FIVE ESTUARIES OFFSHORE WIND FARM

**Appendix J4 to the Natural England Deadline 4 Submission  
Natural England's Comments on the Applicant's Change Request Documents [AS-  
040, AS-048, AS-054, and AS-057]**

Planning Inspectorate Reference EN010115

03 December 2024

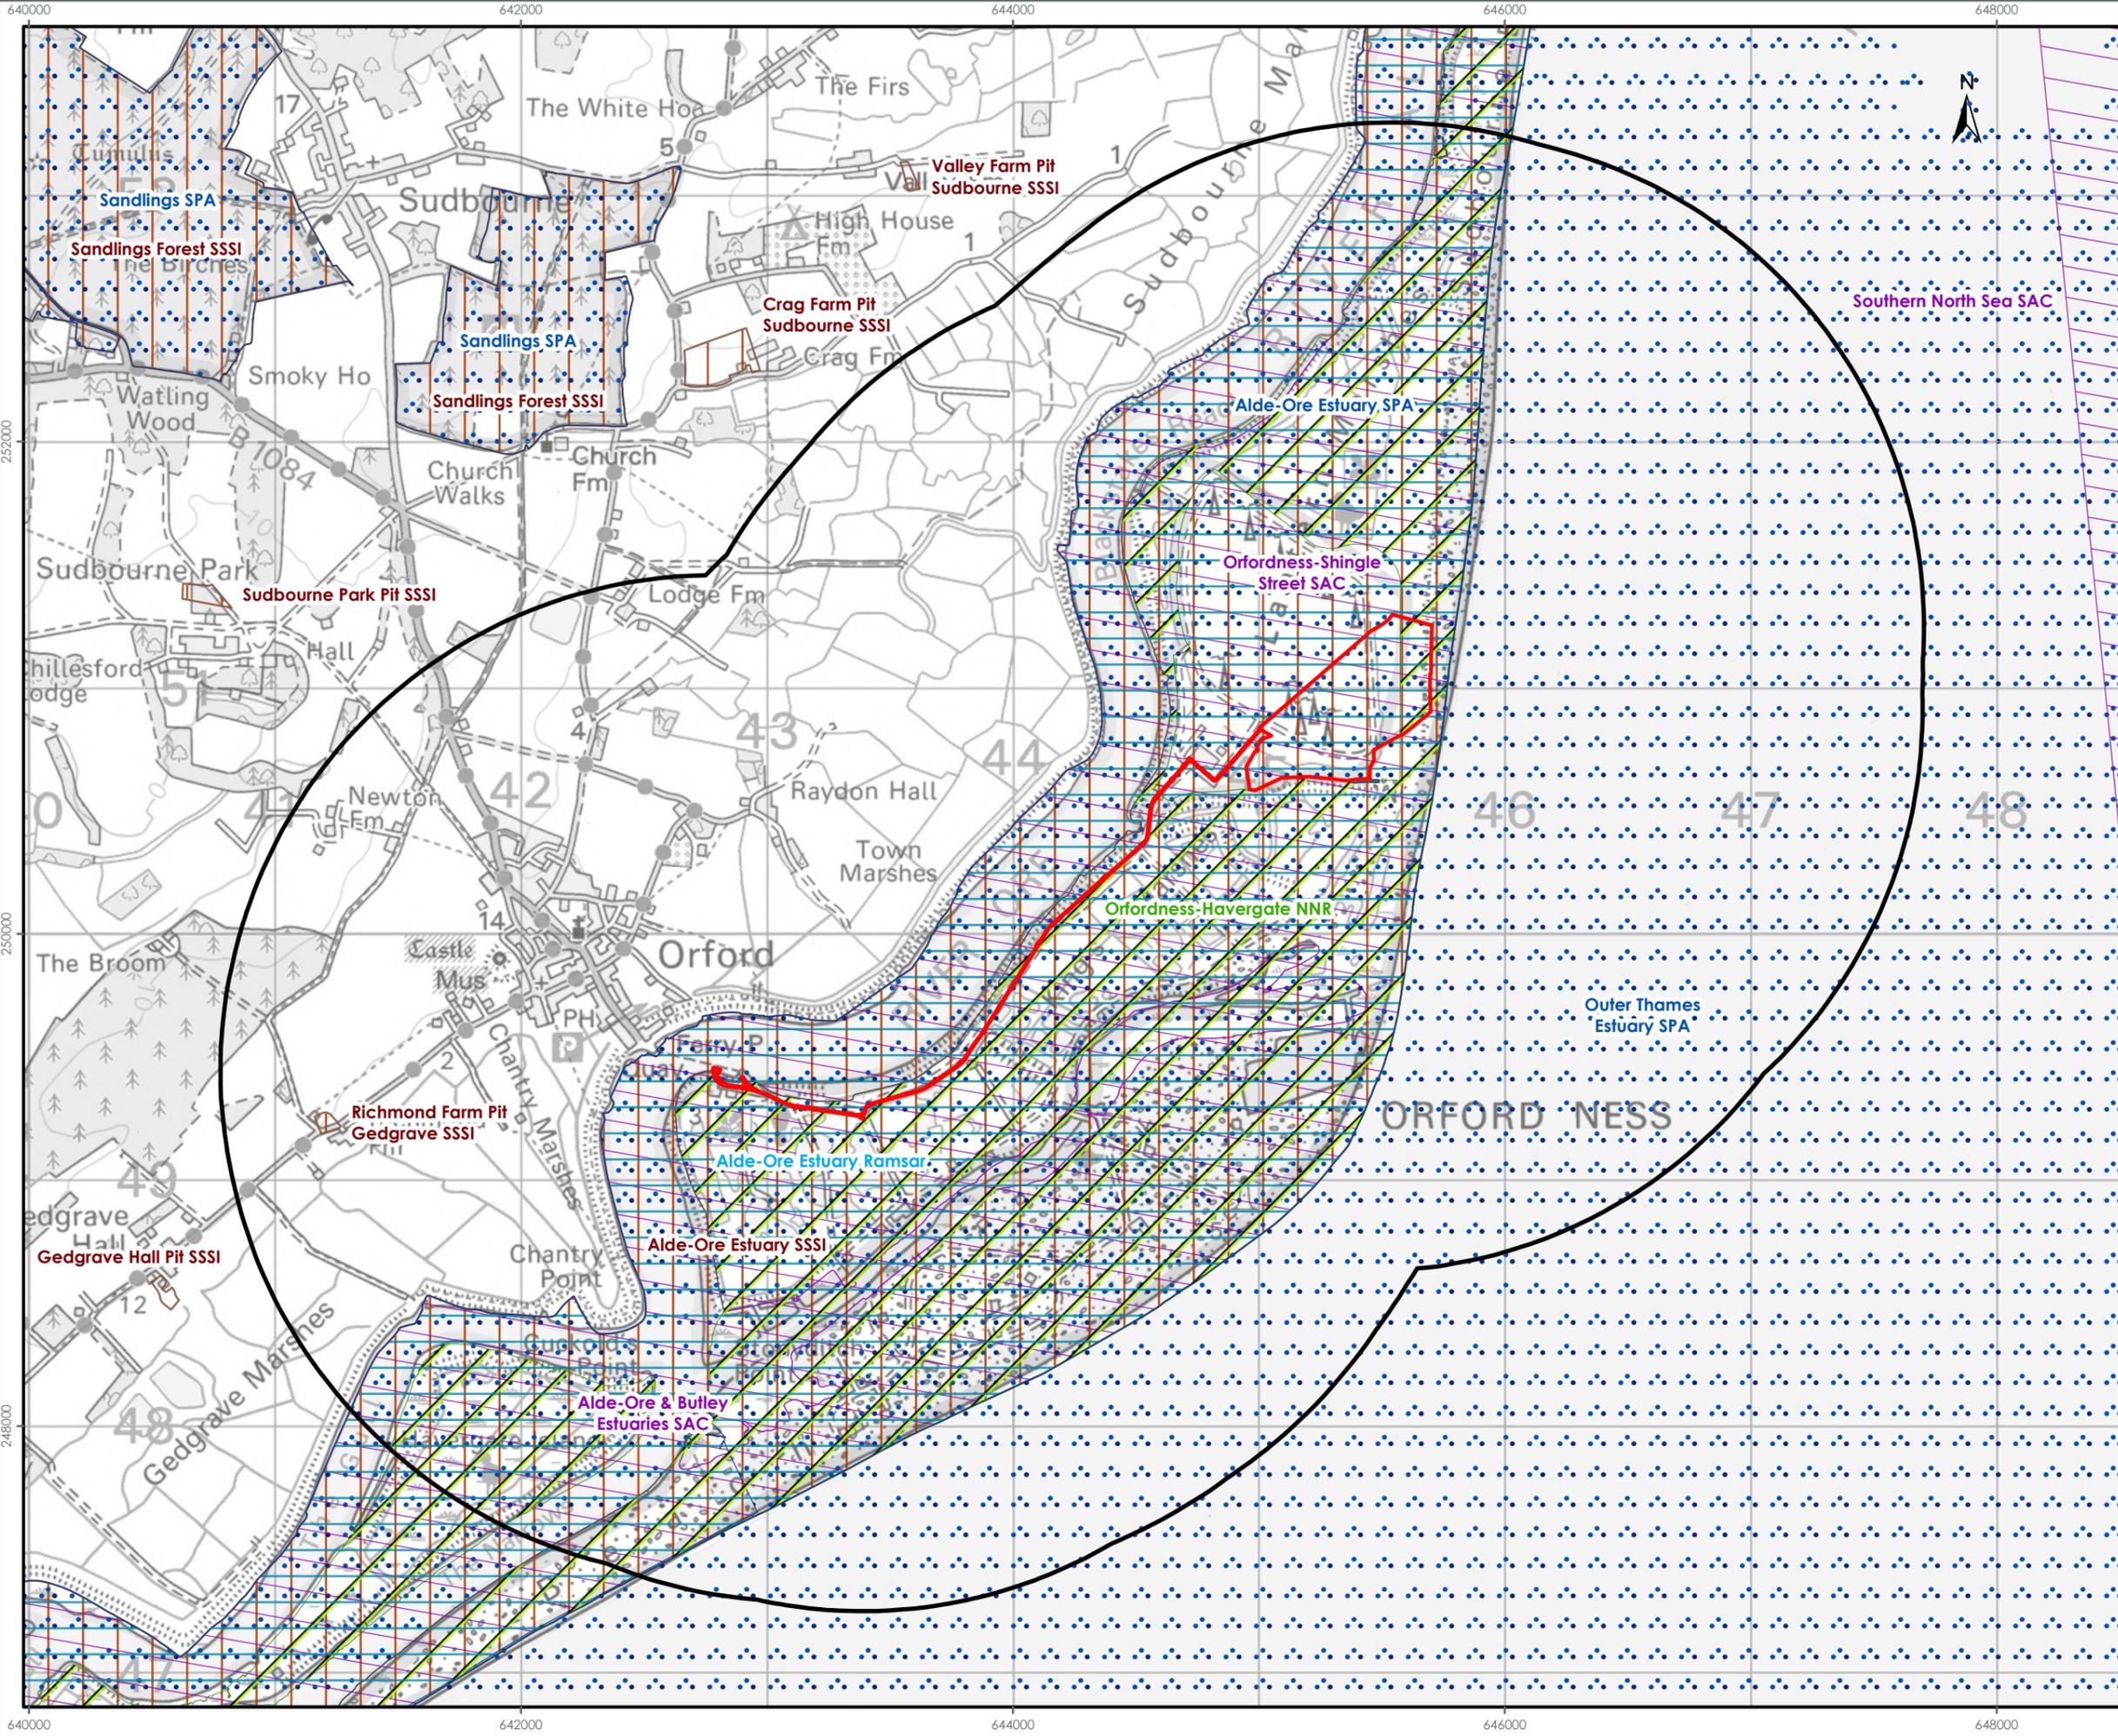
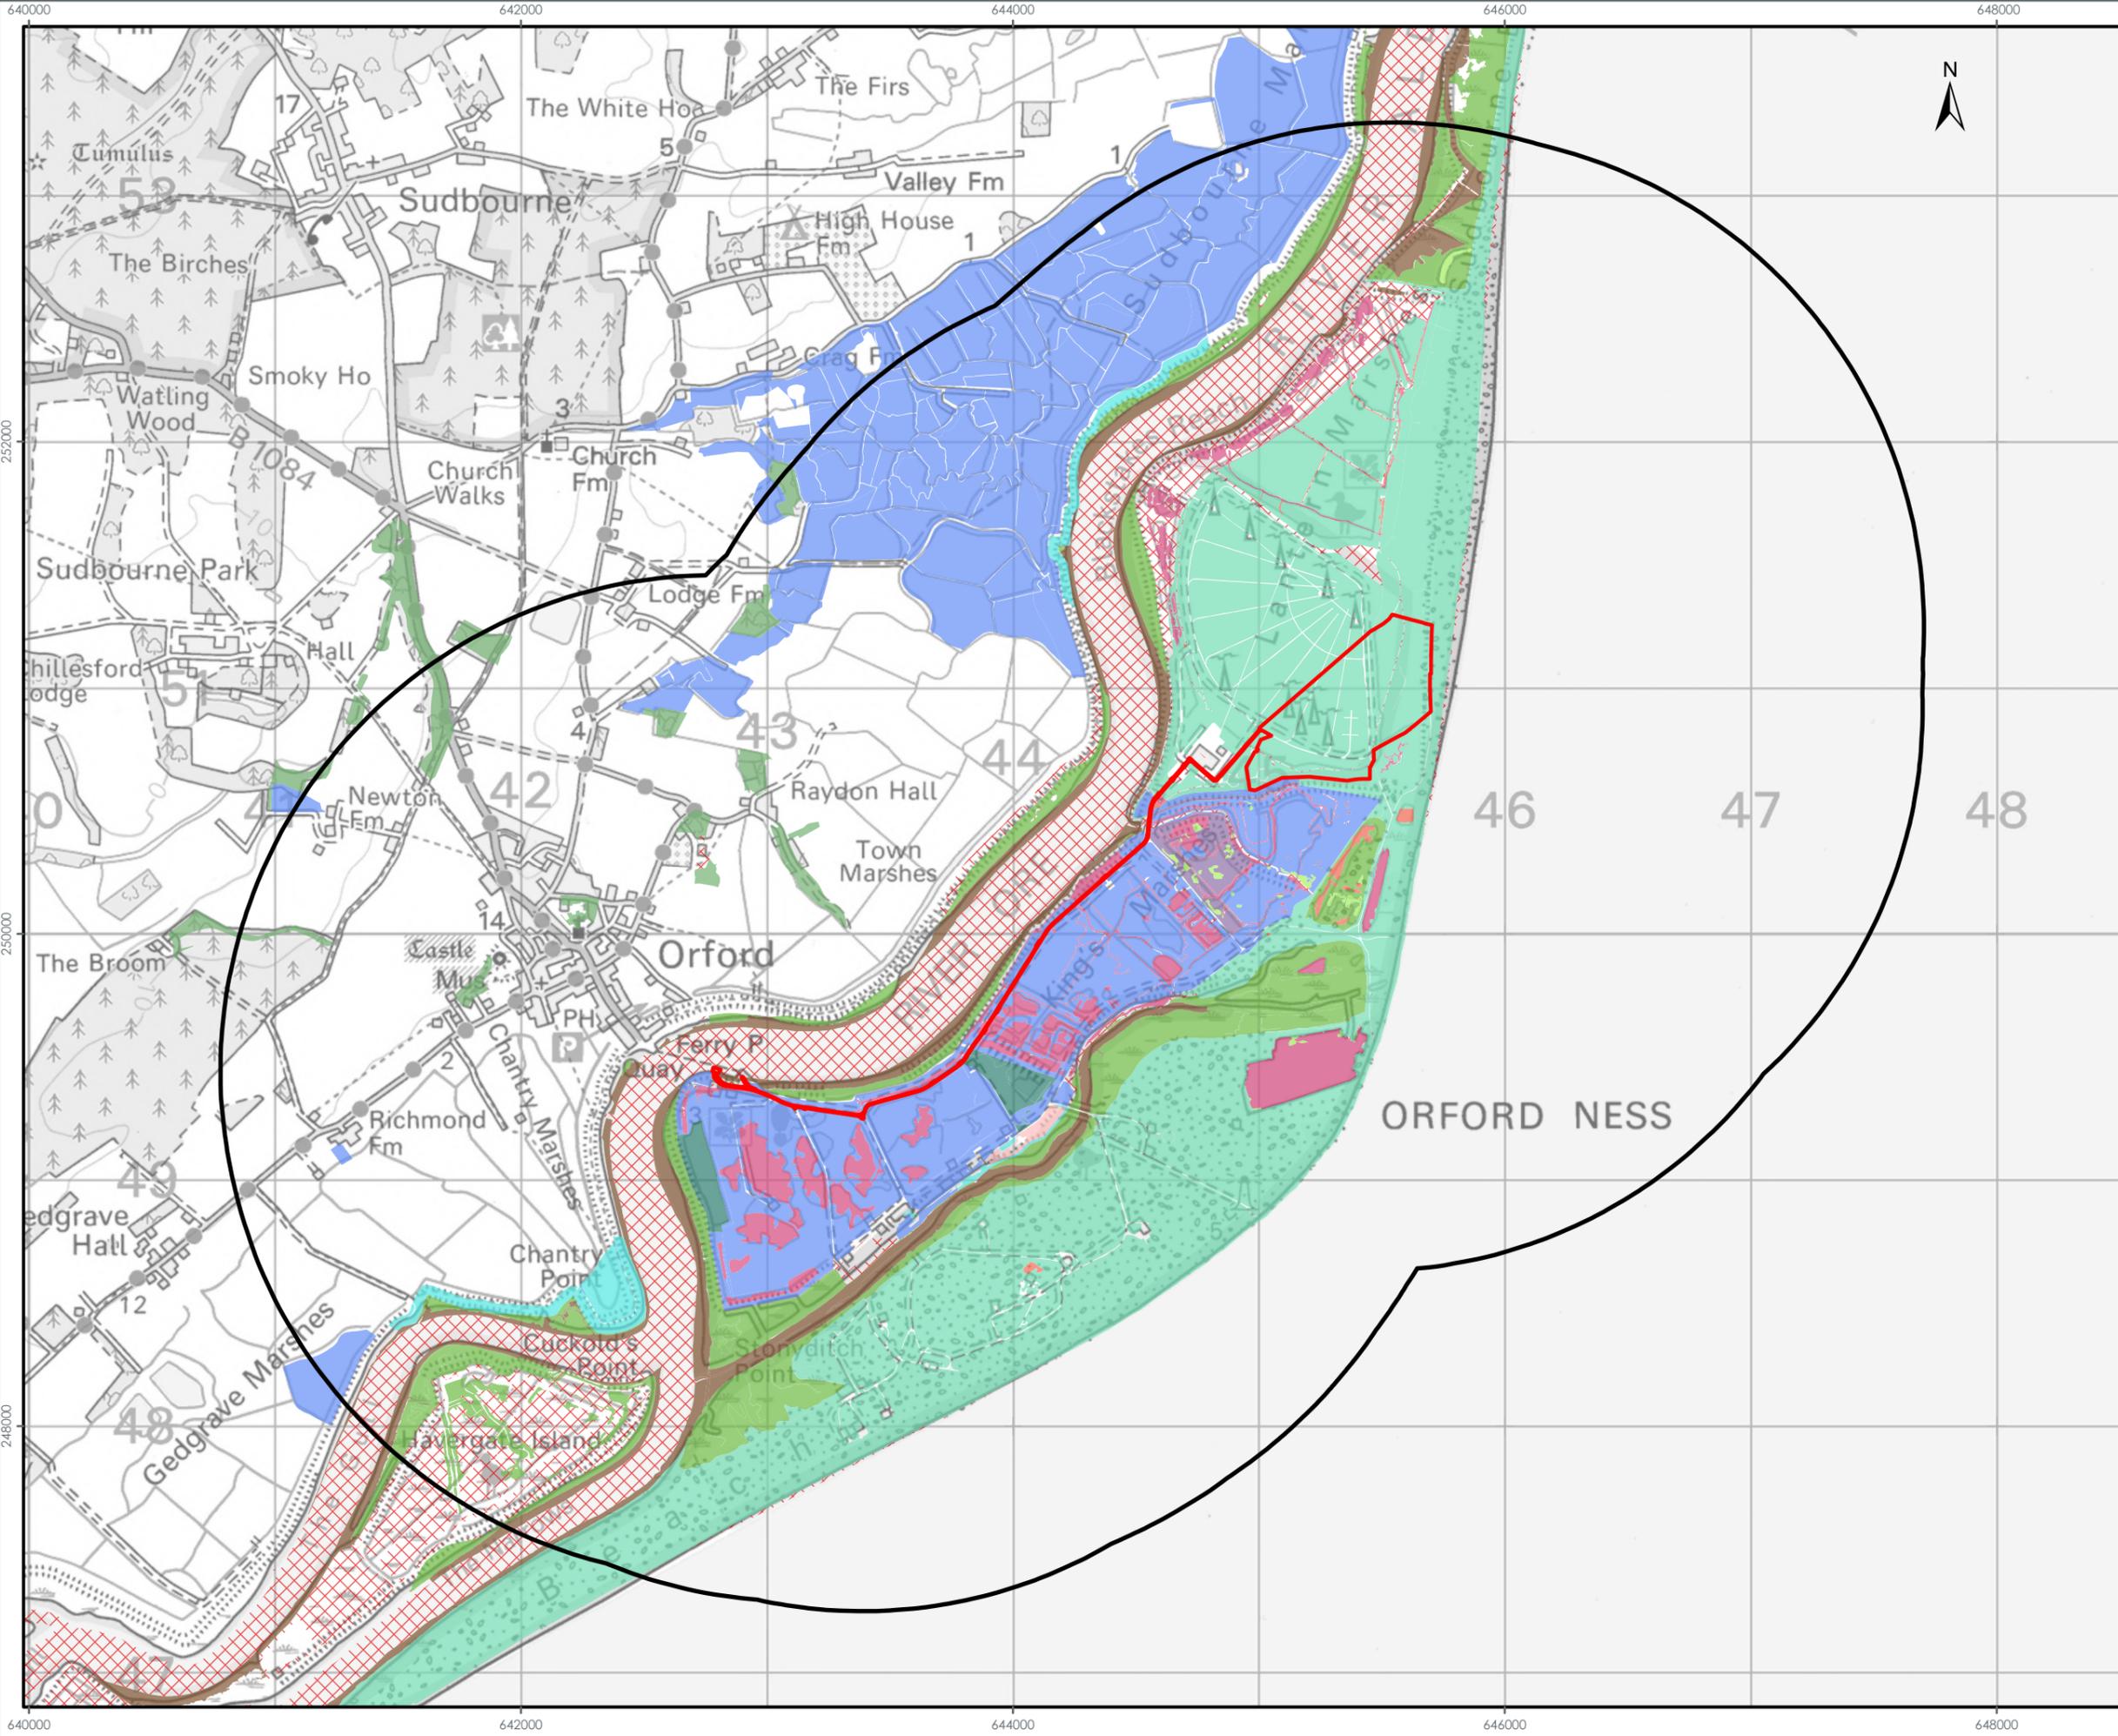
Natural England notes that the map on page 66 shows that more than a third of the current proposed compensation site sits outside of the original survey area. Consequently, without baseline information we are unable to adequately assess the ecological impacts. Furthermore, our earlier comments may need to be revisited, along with those issues previously considered resolved, when the necessary additional information is available.
